ENG-PUDSP21002-R1-TIS.pdf Markup Summary

Figure 3  
**Sight Distance Analysis**  
 Skyline at Lorson Ranch (LSC #204250)

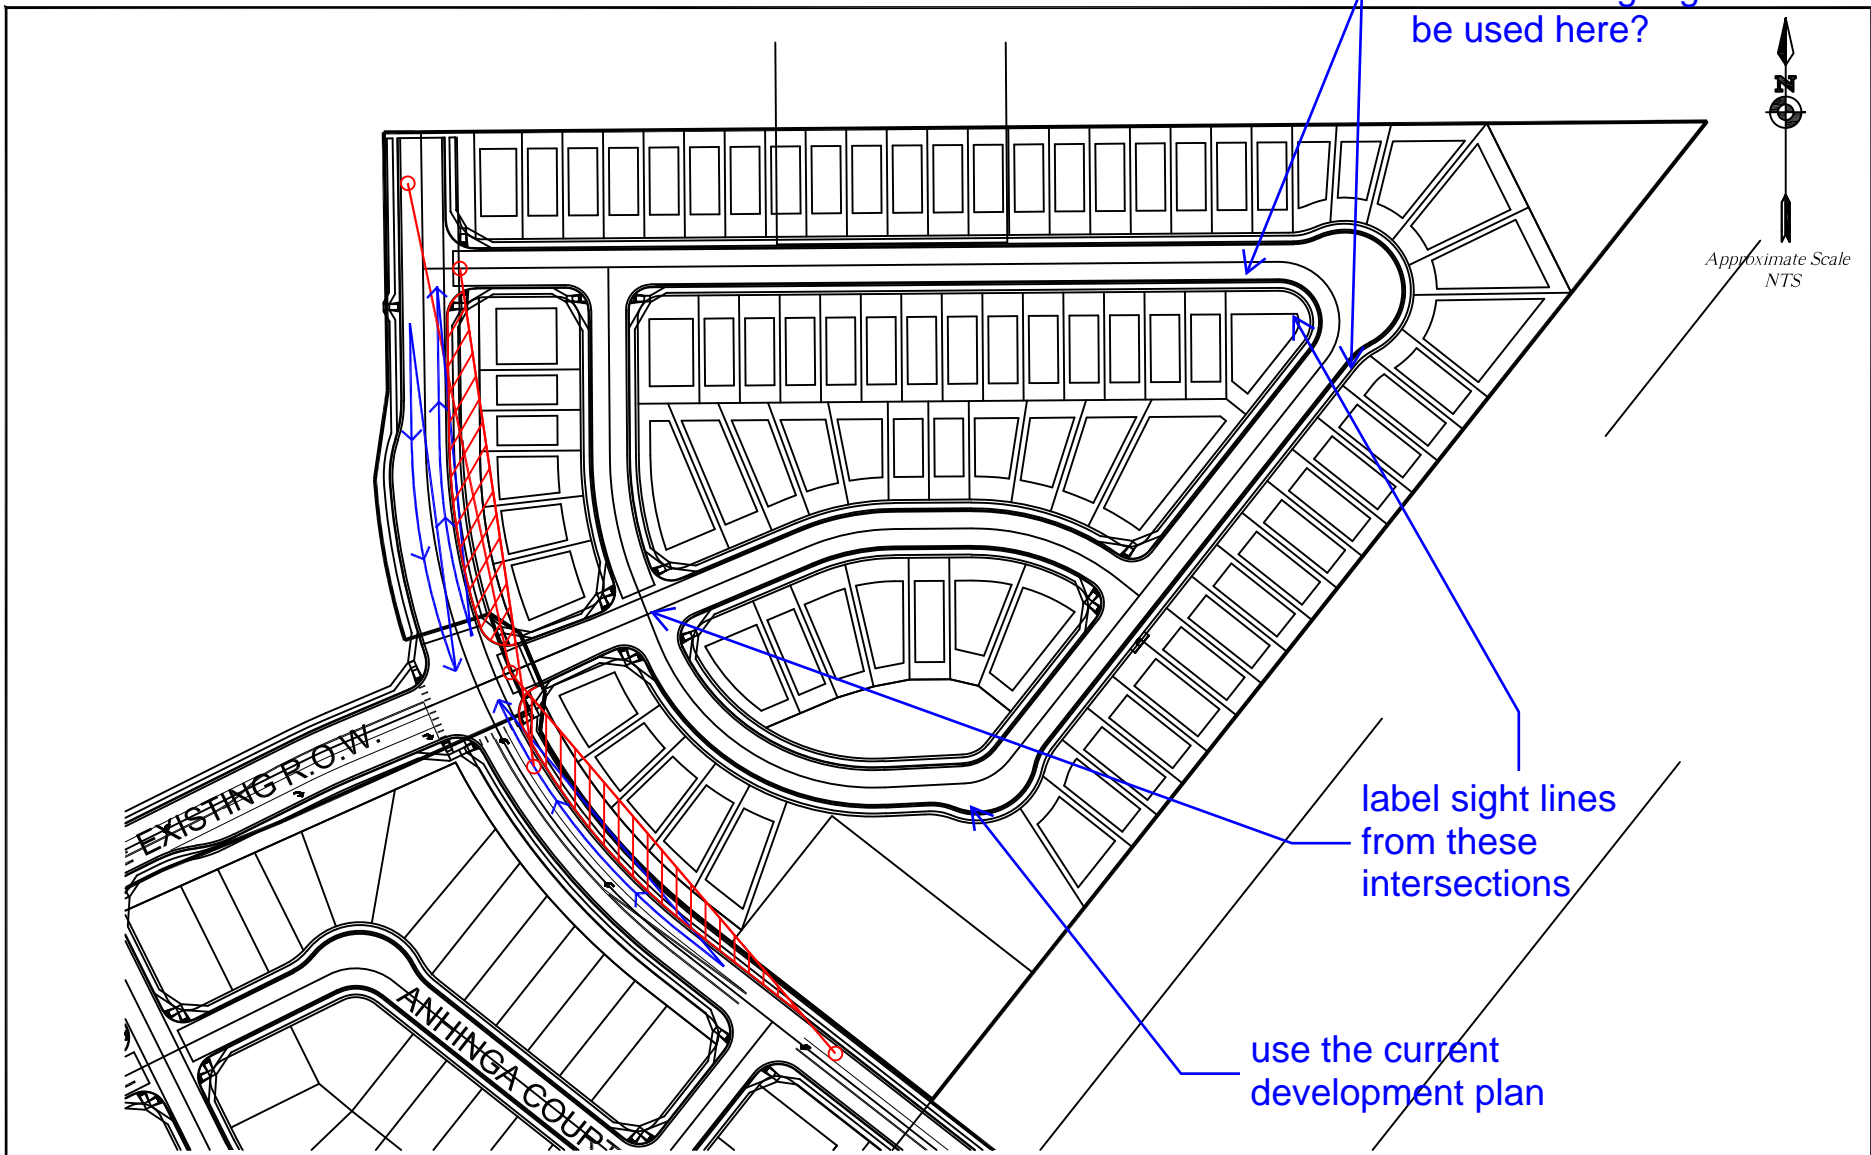
use the current development plan

label sight lines from these intersections

will reduced speed limit/curve signage be used here?
